CITY OF ALBUQUERQUE

**Re: Pueblo Viejo, No Address Provided, Traffic Circulation Layout
Architect's Stamp dated 06-05-12 (J13-D024)**

Based upon the information provided in your submittal received 06-05-12, the above referenced plan cannot be approved for Building Permit until the following comments are addressed:

REVISION DATE	
DATE	06-05-2012
SHEET NUMBER	C-1.0

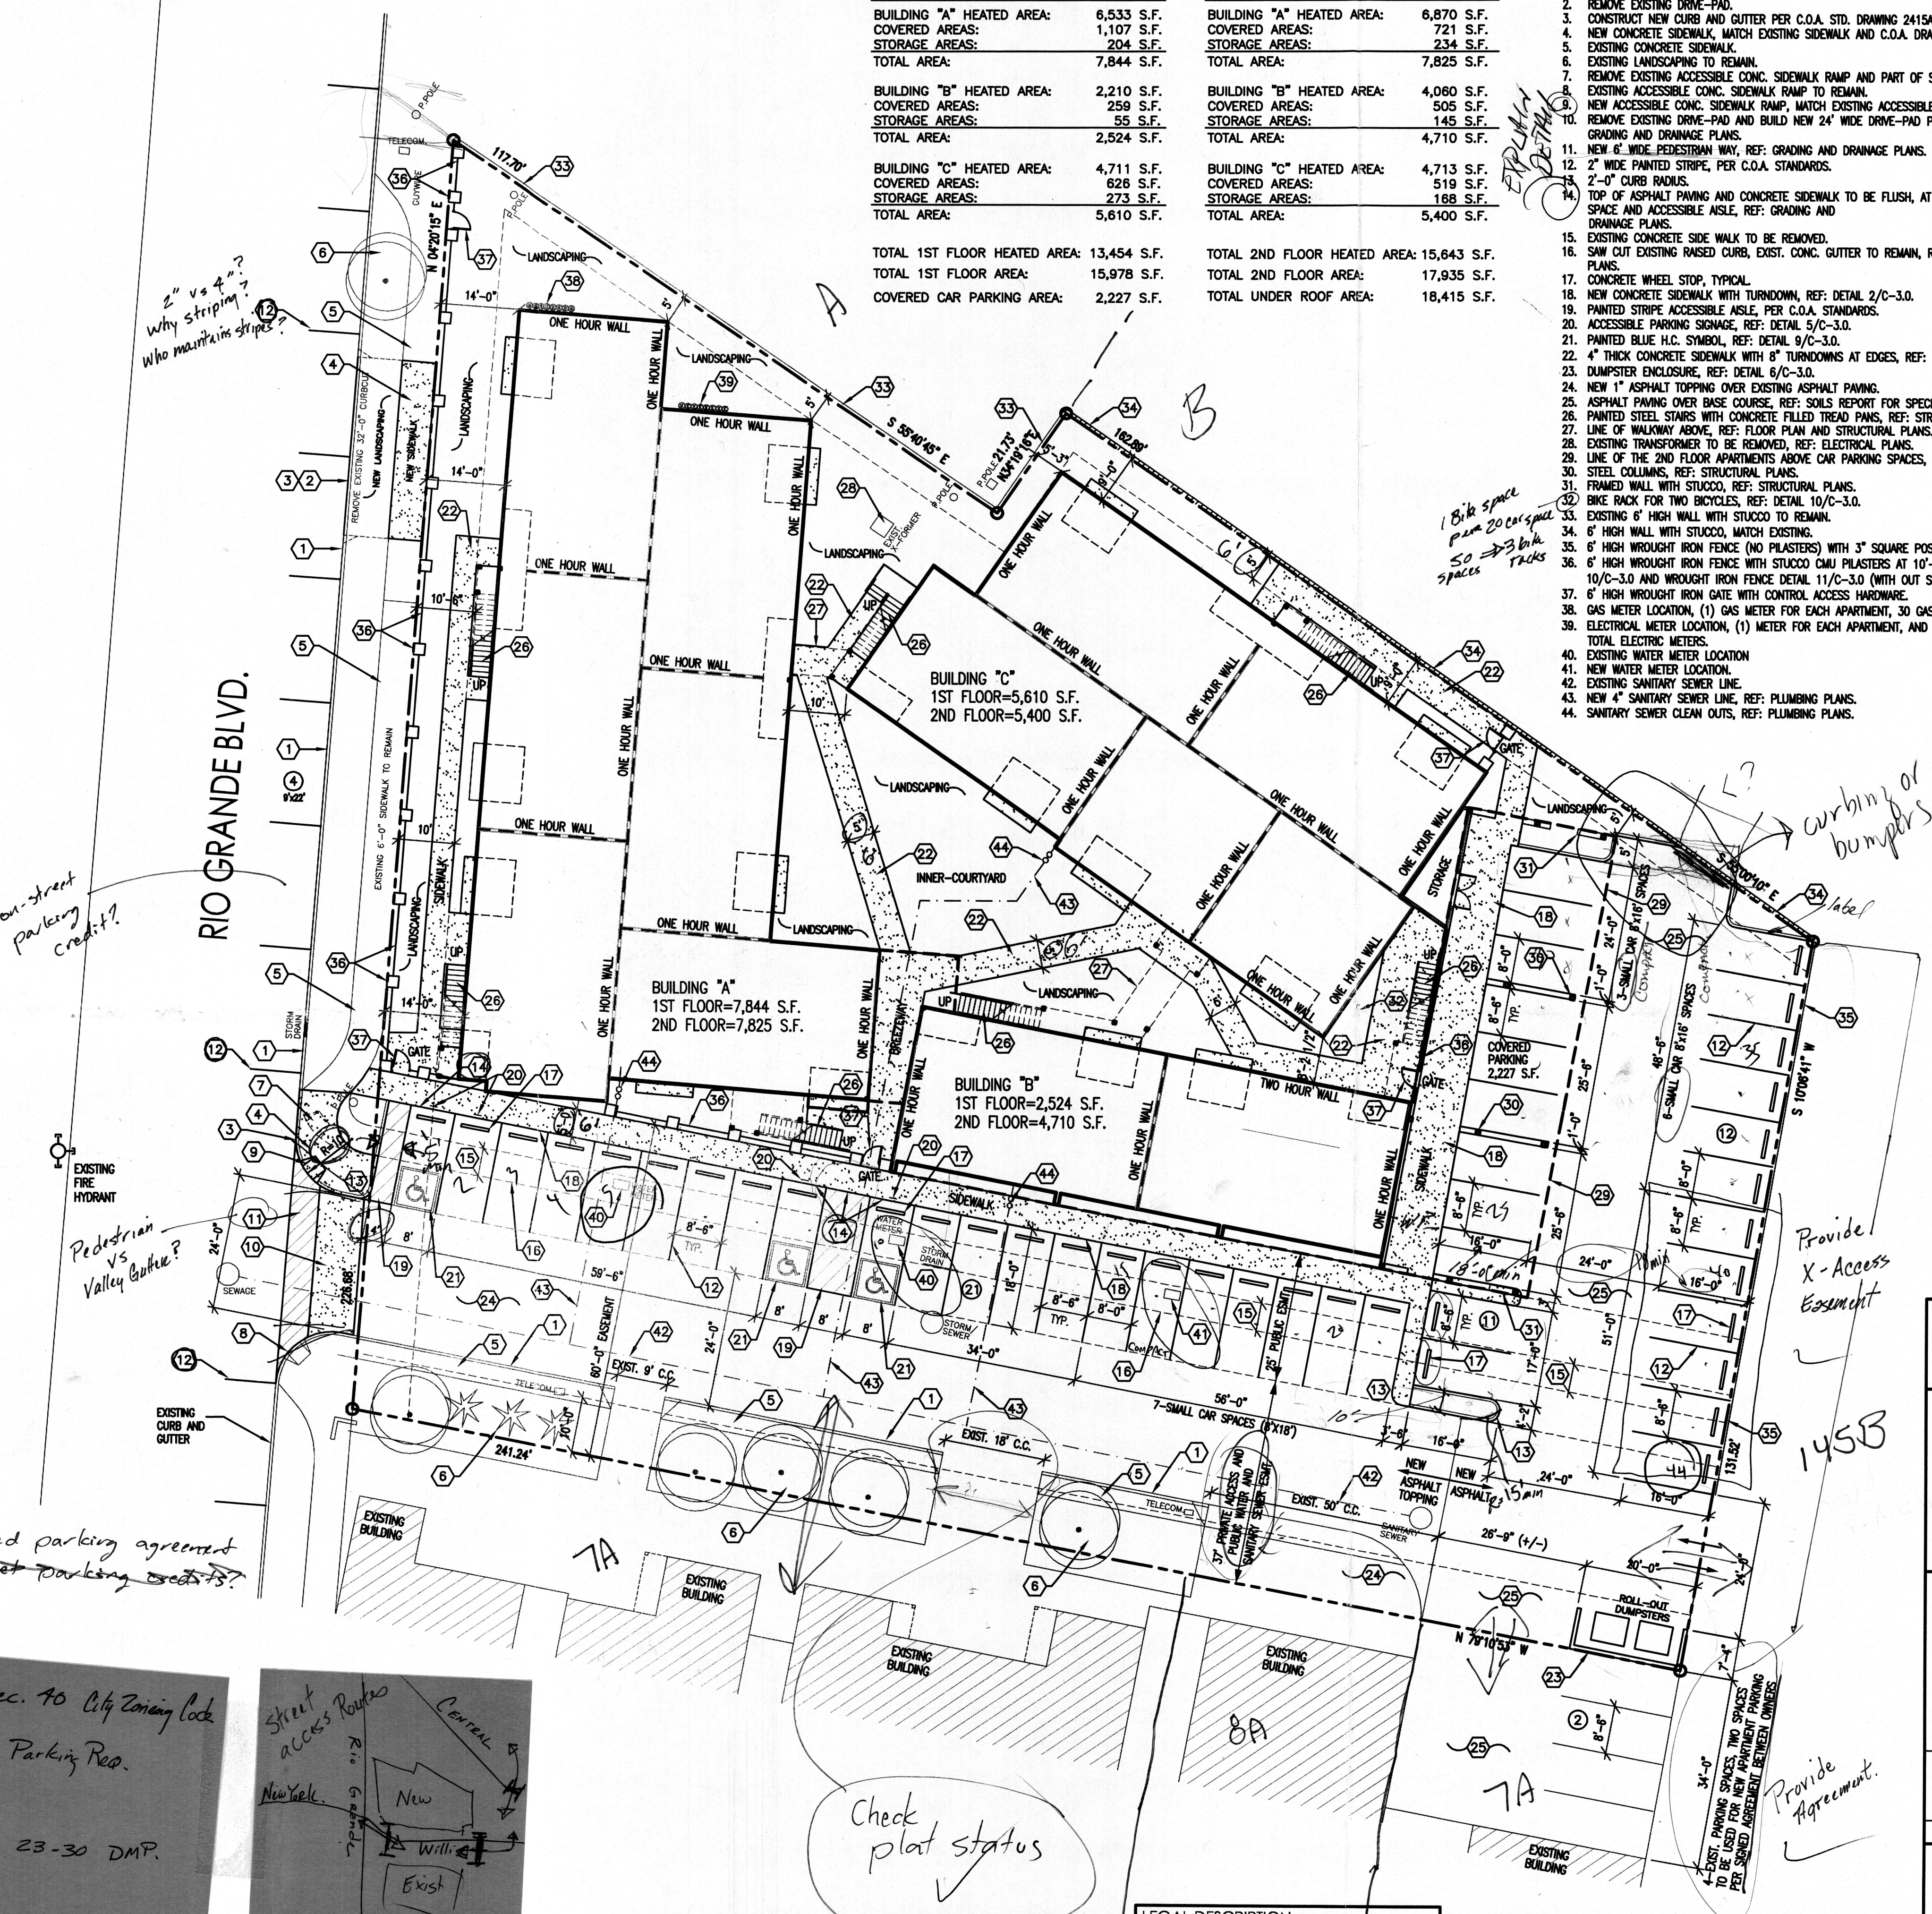
2. Clearly show all adjacent lot lines. Identify all adjacent lots.
3. Access easements are shown with Lots 7A, 7B, and 145B. These easements must be recorded, preferably with the platting action, prior to approval.

4. Clearly show how access will be shared with lot 145B. Does lot 145B access Central directly?
5. What is the address for the site?
6. This site was approved for 4 on-street parking credits on March 26, 2012. However, Transportation Development did not approve striping the parking stalls on the roadway. Please remove all on-street striping.

8. List radii for all curves shown; for passenger vehicles, the minimum end island radius is 15 feet.
9. Existing and proposed water meters are shown in the proposed parking stalls (see keyed notes 40 and 41). Are these meters traffic rated?

10. The handicapped spaces must include an 8-foot wide van access aisle; all other aisles should be 5 feet in width.

11. Label the compact parking spaces by placing the words "compact" on the pavement of each space.
12. A standard parking stall is 18 feet long, with a maximum 2-foot overhang. Overhang is not permitted across the property line.

13. Define width of all sidewalk, existing and proposed.
14. Keyed note 10 refers to City of Albuquerque Standard 2425; please revise to refer to City of Albuquerque Standard 2426.

15. Provide a legend, defining all linetypes and hatching.
16. Keyed note 11 defines a pedestrian way. However, this appears to be a valley gutter. Please remove proposed striping.

17. All sidewalks within the site must be 6 feet in width.
18. Clarify how vehicles will maneuver within the dead end parking aisle.
19. Per the *Development Process Manual*, Chapter 27, Section 2, Part B.1, only the following scales may be used:
